October 4, 2022

Re: Public Comment Overview - File No. 2207-019 / 6950 SE Maker Street / Parcel
No. 9350900620

We are commenting on this proposed project because we believe the GFA calculation and the existing grades designated by the applicant do not comply with the Mercer Island City Code (MICC). We also have several concerns and questions for the City that pertain to the geotechnical and storm drainage report of which we request be answered. Additionally, due to the complexity of the proposed project, site considerations by the geotechnical consultant, and tight confines of Maker Street, we are requesting the City require a Construction Management Plan be filed. And lastly, based upon our understanding, the MICC tree code may have been violated, and we've provided information pertaining to that issue.

MERCER RESIDENCE  
6950 SE MAKER ST MERCER ISLAND, WA

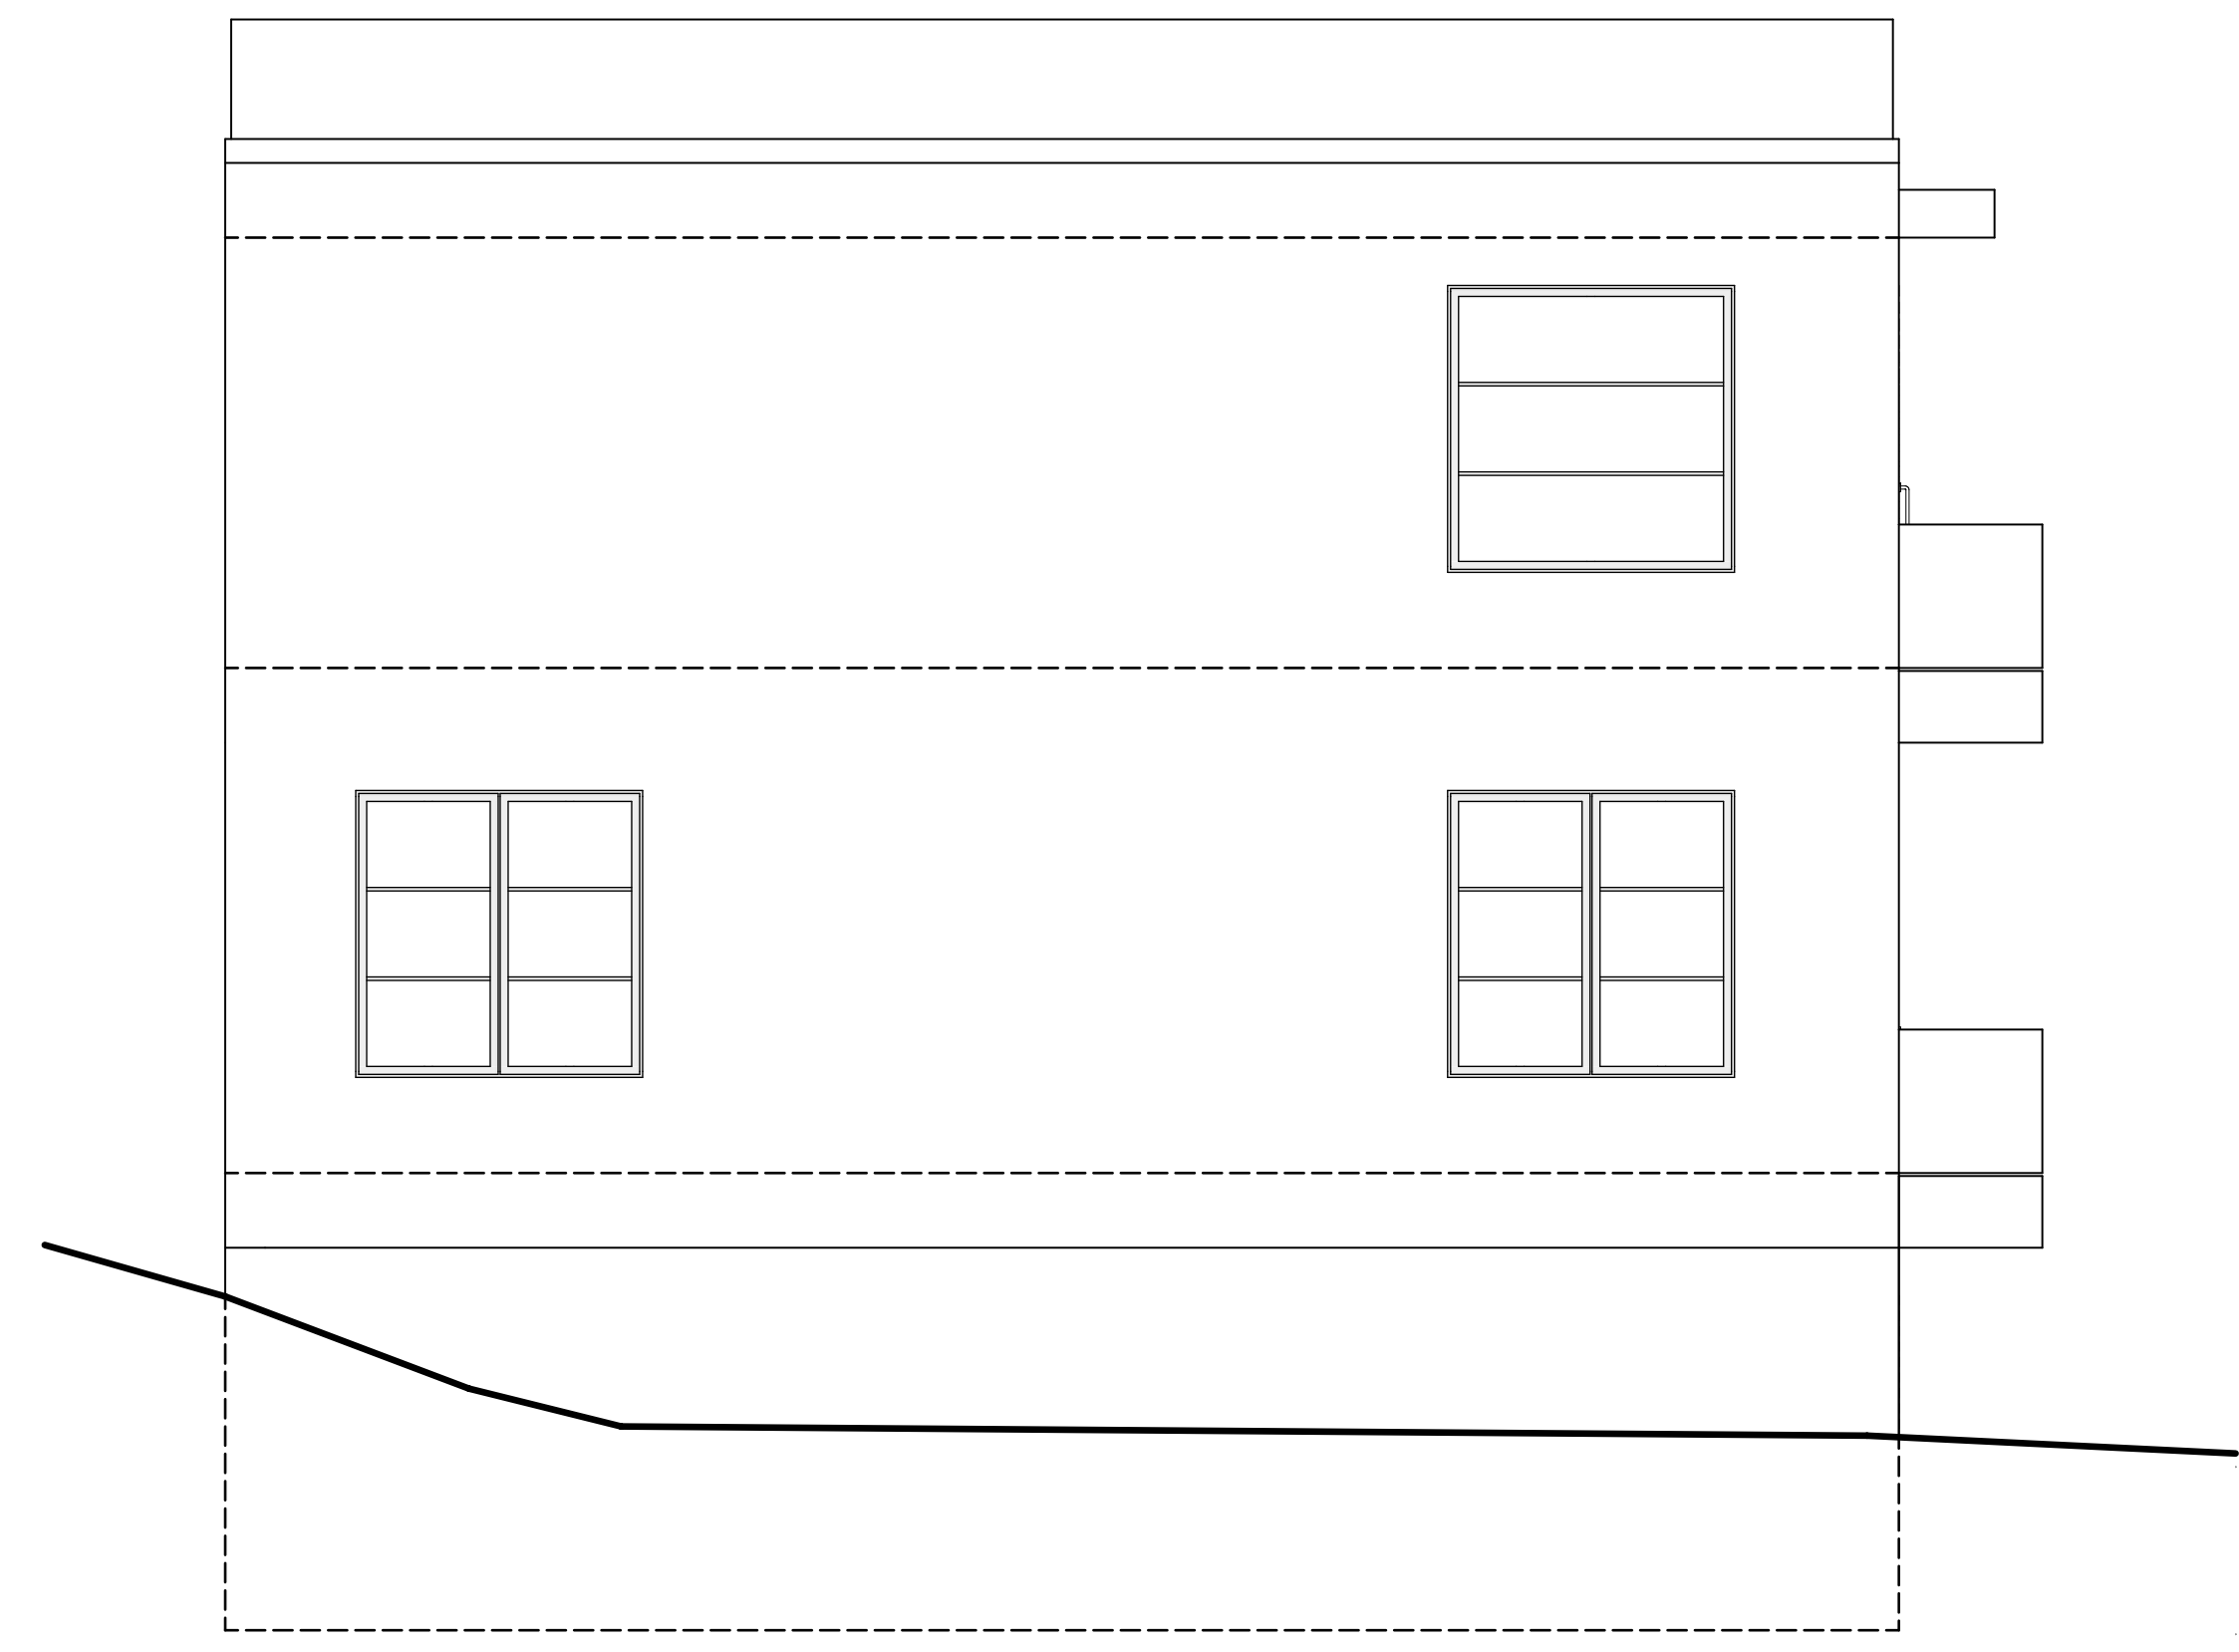
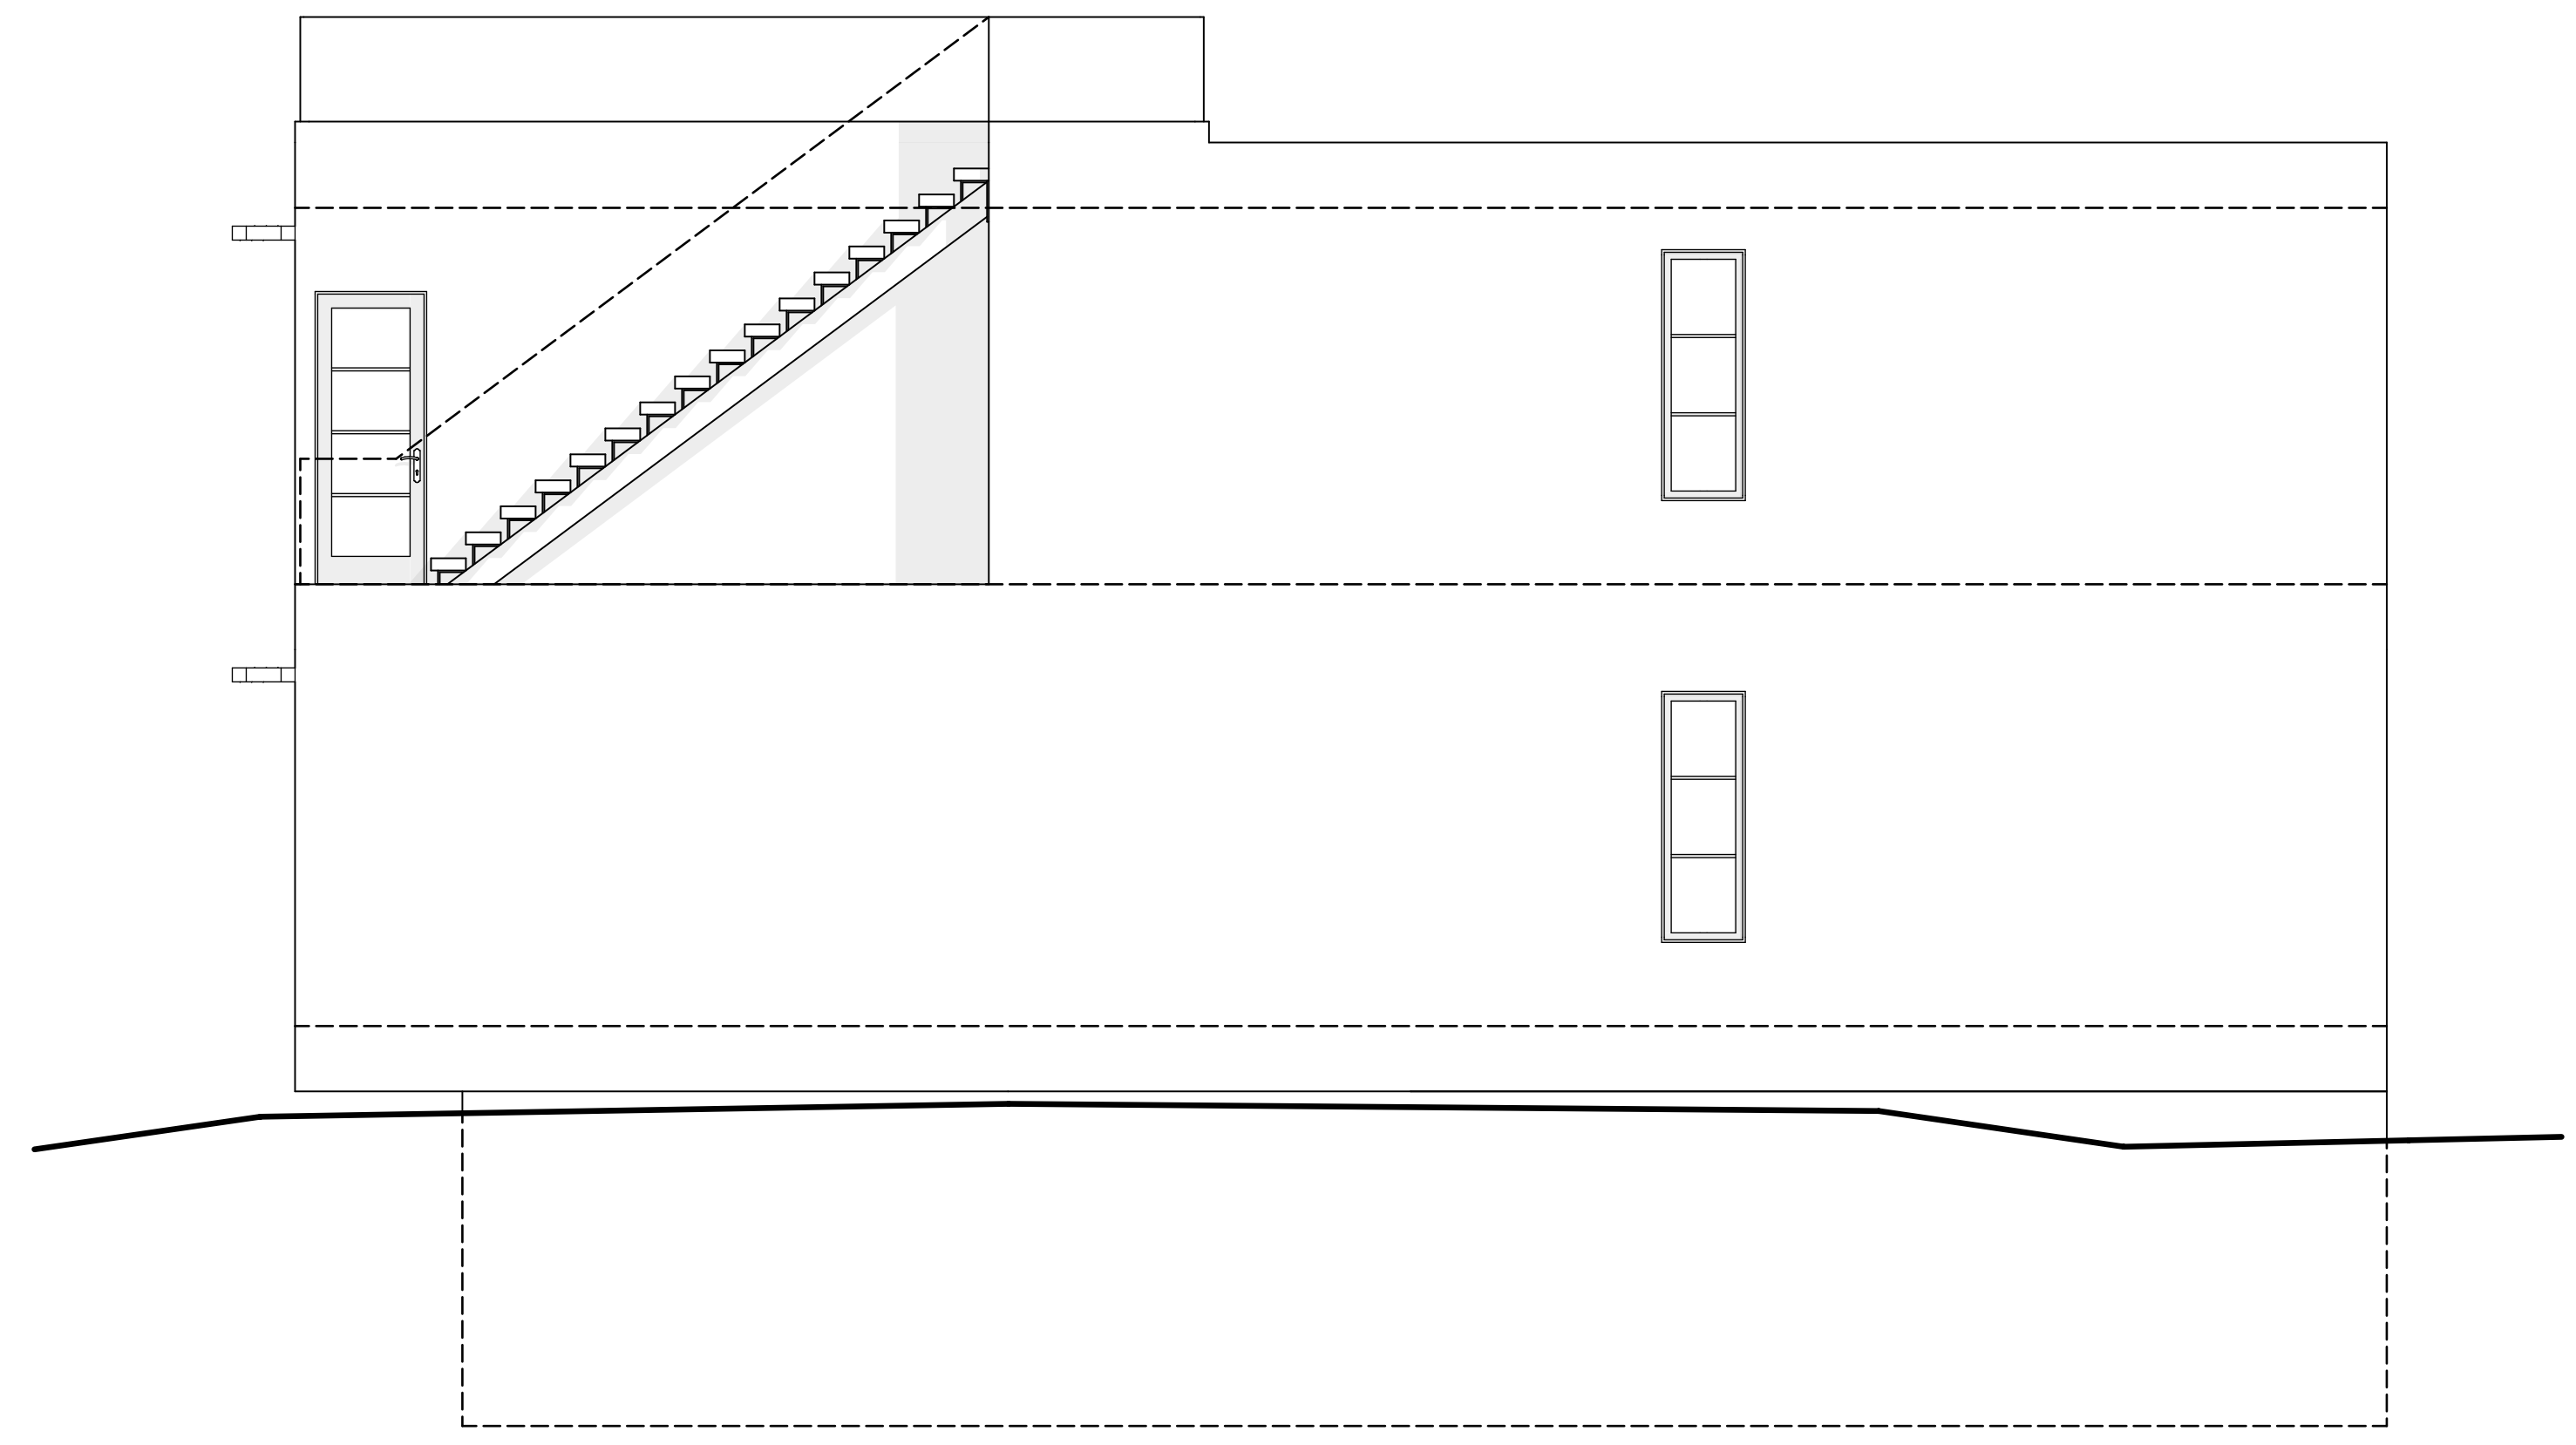
Though the existing grade elevations were not shown on the three of the elevation drawings, existing elevations were used from the survey drawing to gain approximate grades. And where "proposed finished grades" were lower, as per Appendix B - Basement Floor Area Calculation, we used those at the garage front and entry and the basement patio door. A copy of our calculations are included in the attachments.
